13 January 2021

Ref: Planning Application AB/109/20/HH – White Cottage, 32 King Street, Arundel BN18 9BW

Case Officer Mr Z Denton
Case reference AB/109/20/HH
Extension - White Cottage 32 King Street Arundel BN18 9BW
Objection
Planning online comments ref: OWPC31410 (part one) and OWPC31411 (part two)
With supporting attachments

PROPOSED ELEVATIONS

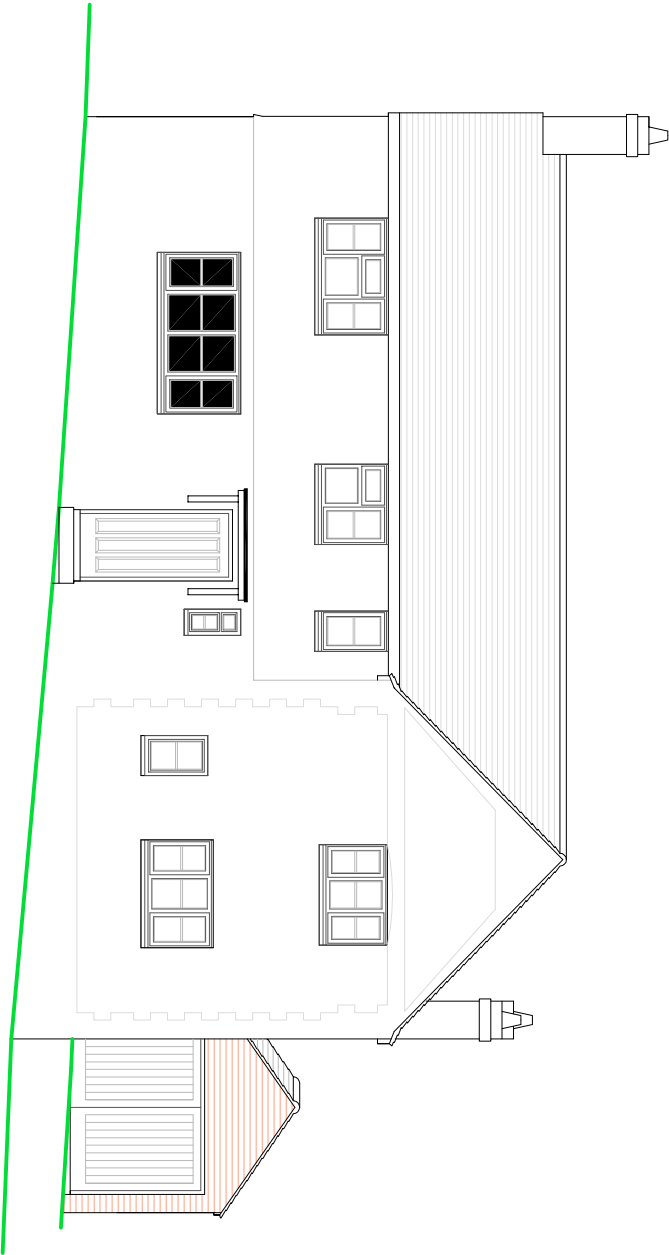
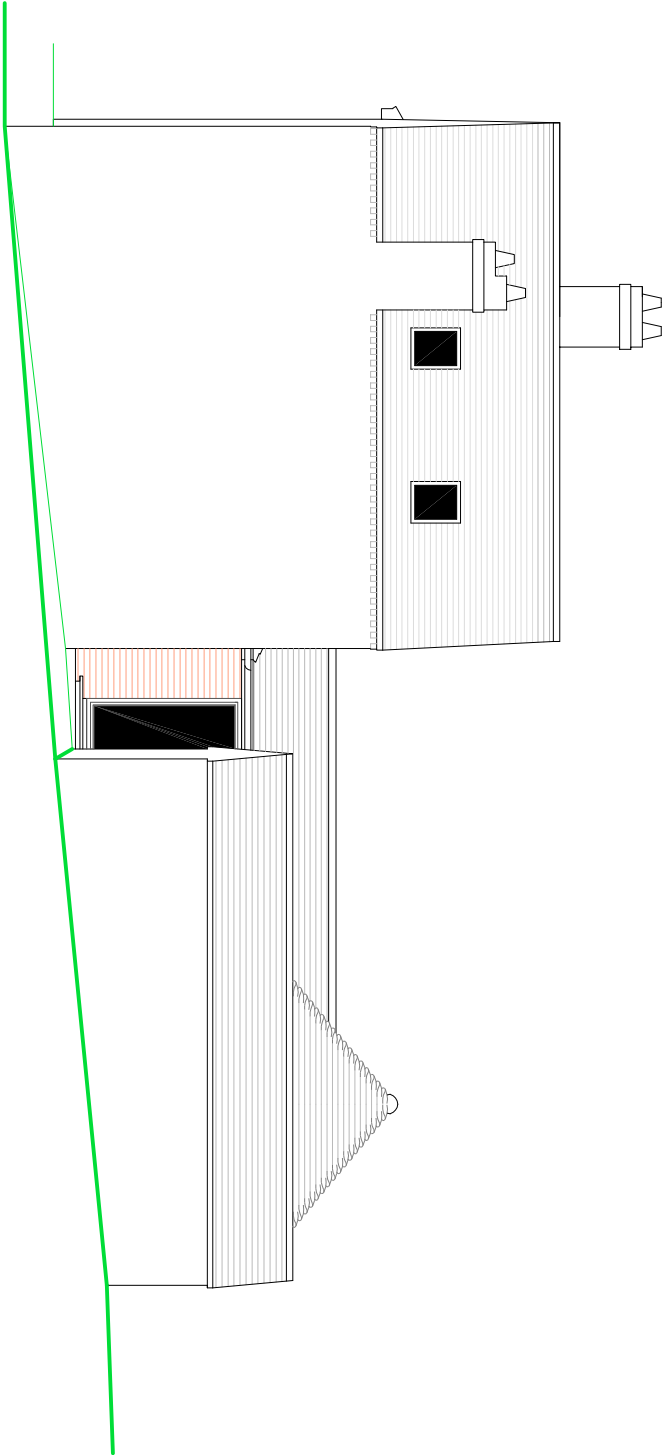
The Applicant proposes to take out 7-8 metres of this unique hedge together with all the wildlife habitats and established wildlife corridors, runs and trails and replace it with a blank brick wall, 4 metres in height with a truncated pitched roof of a further 1.5 metres. This wall would be on the boundary line, 1.4 metres from my client's property and his Living room and Study windows, which for 250 years have had quiet enjoyment of the garden and beech hedge through which the sunlight filters.

No 32/34, White cottage, was built with its Eastern wall held back for the preservation of light to the windows on the South elevation of the listed building at No, 36. Therefore No further construction can take place on the boundary between 32/34 and 36 as proposed. The height of the proposed wall would preclude light to all windows on the south elevation. This prescriptive right dates back to Circa 1690.
